**Harnett County**  
420 McKinney Pkwy  
LILLINGTON, NC 27546  
Phone:  
Fax:

SUBJECT: **BRES2301-0075**  
**BUILDING RESIDENTIAL**

Here are the results of all Inspections located at **1231 MURCHISONTOWN RD:**

**MATING WALL TENSION CONNECTION**

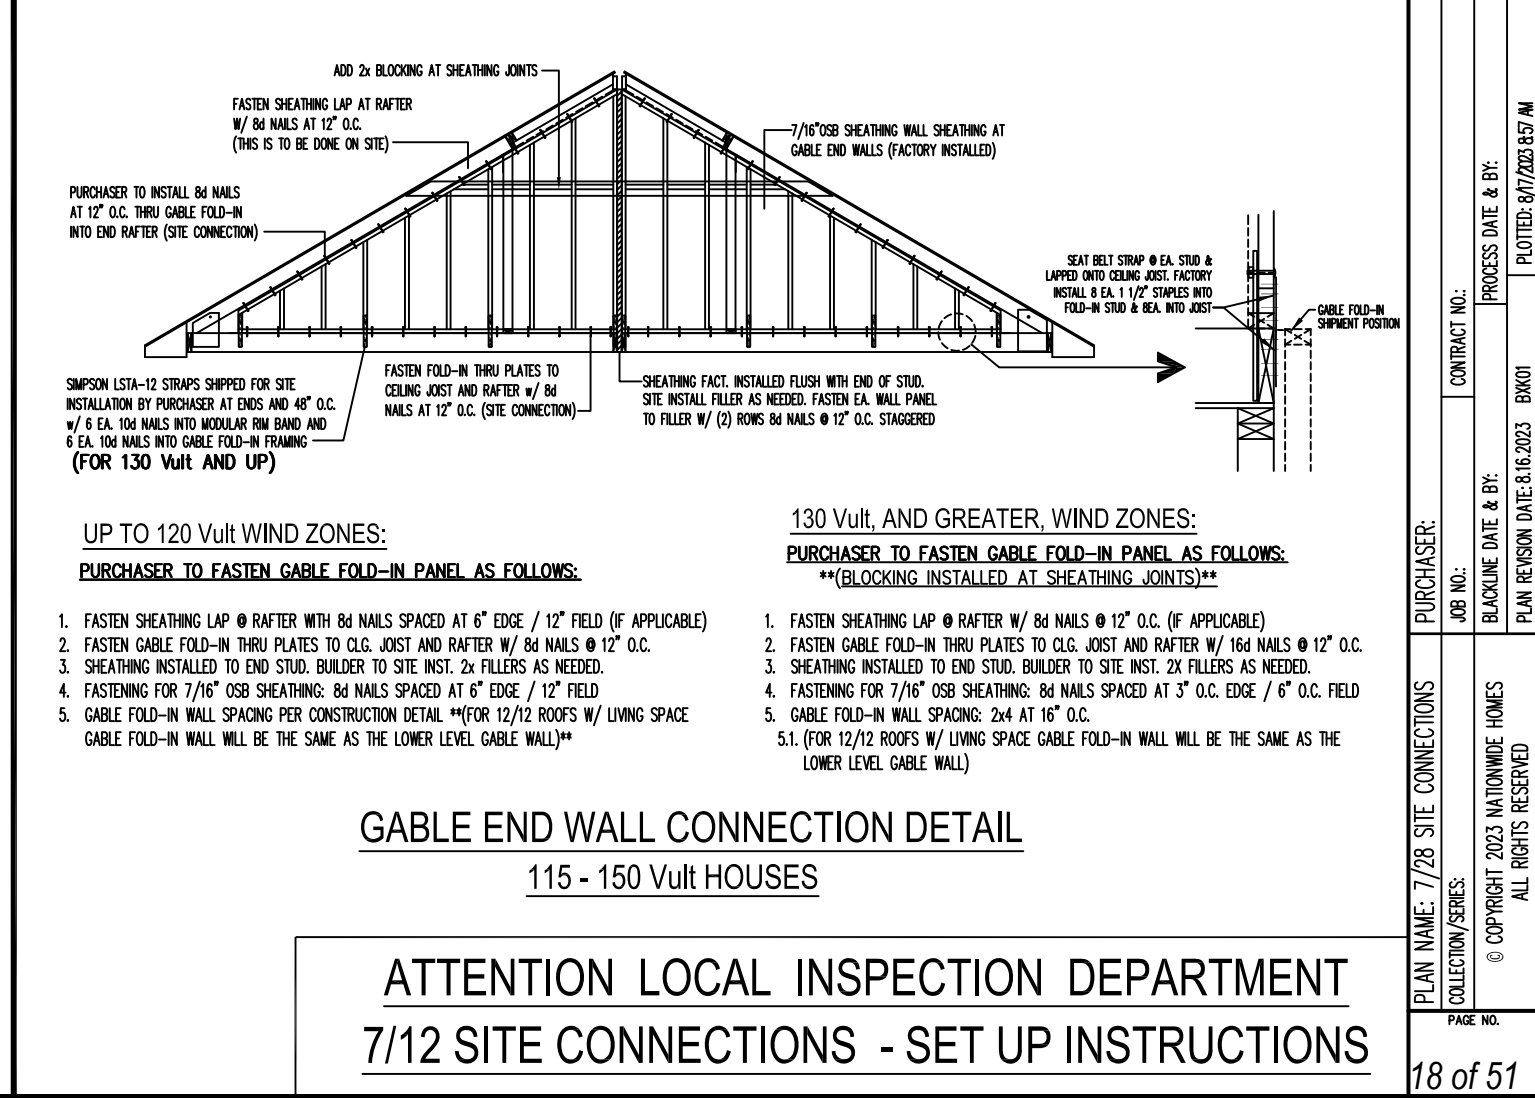
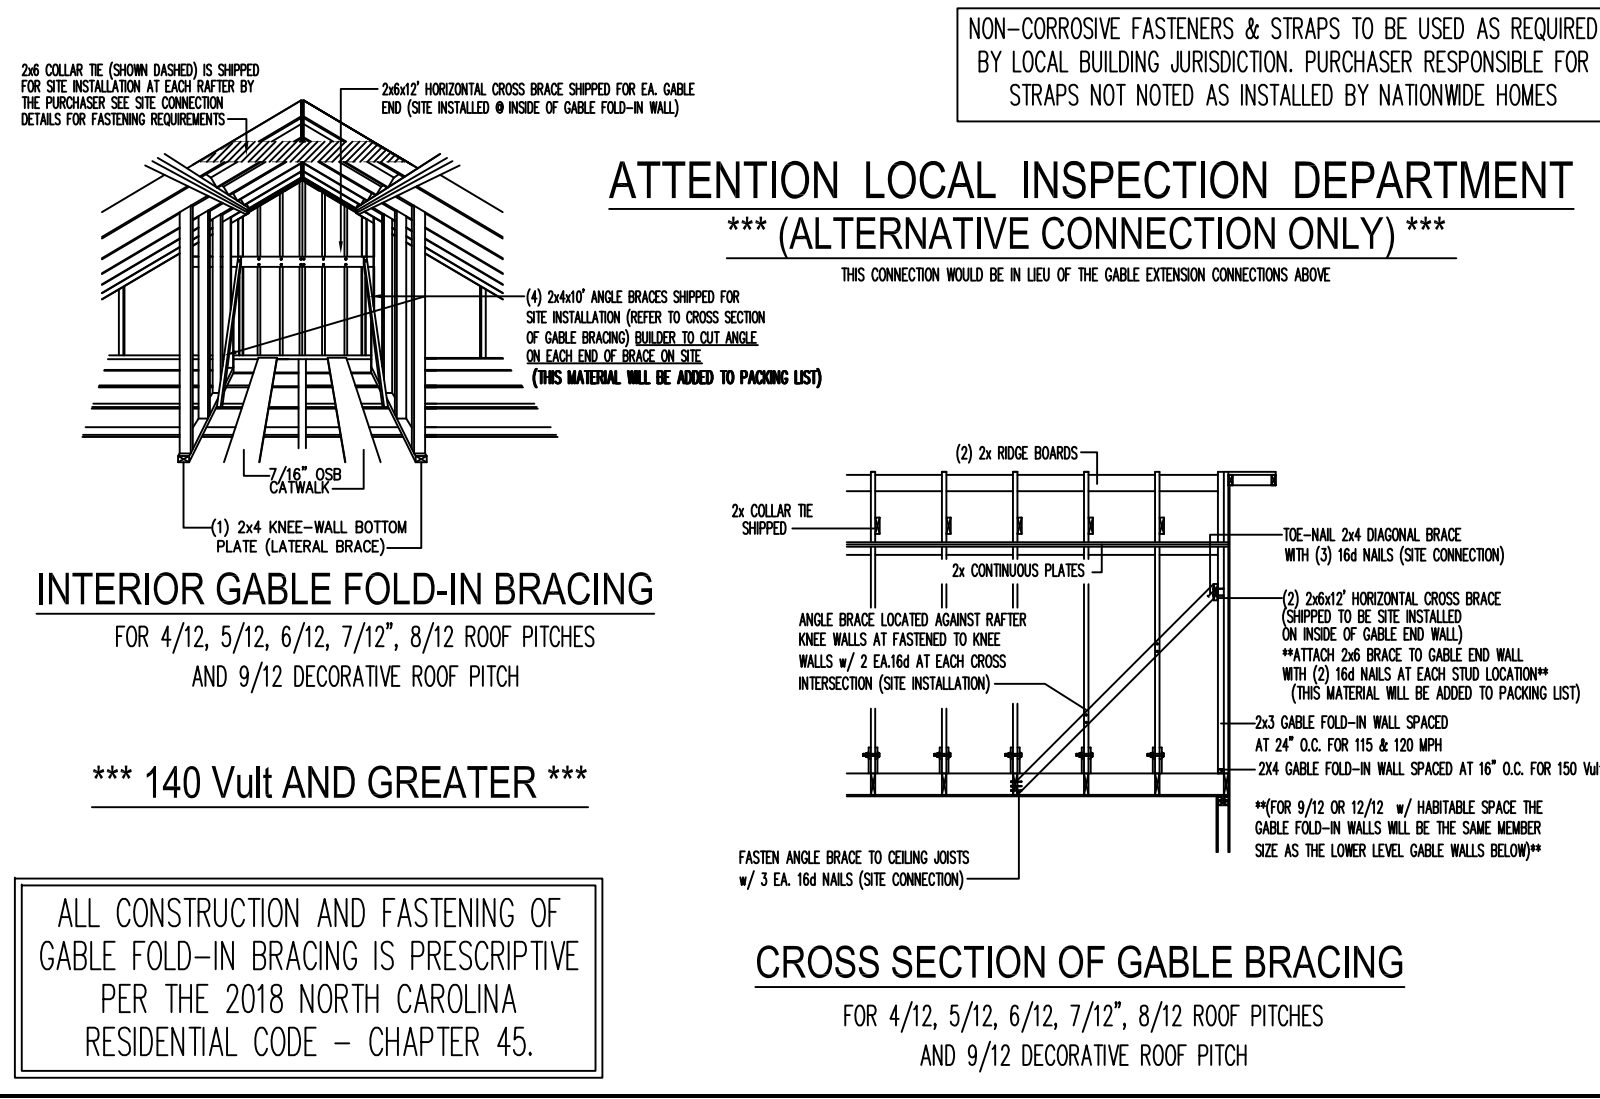
Inspection Type: MARRIAGE WALL  
Scheduled Date/Time: 3/18/2025  
Completed Date/Time: 3/18/2025  
Inspector: Ricardo D Honrada  
Result: DISAPPROVED  
Remarks:  
Notes: LOCK BOX 4760  
Need follow as per plan detail H metting wall tension connection. Need portable toilet.
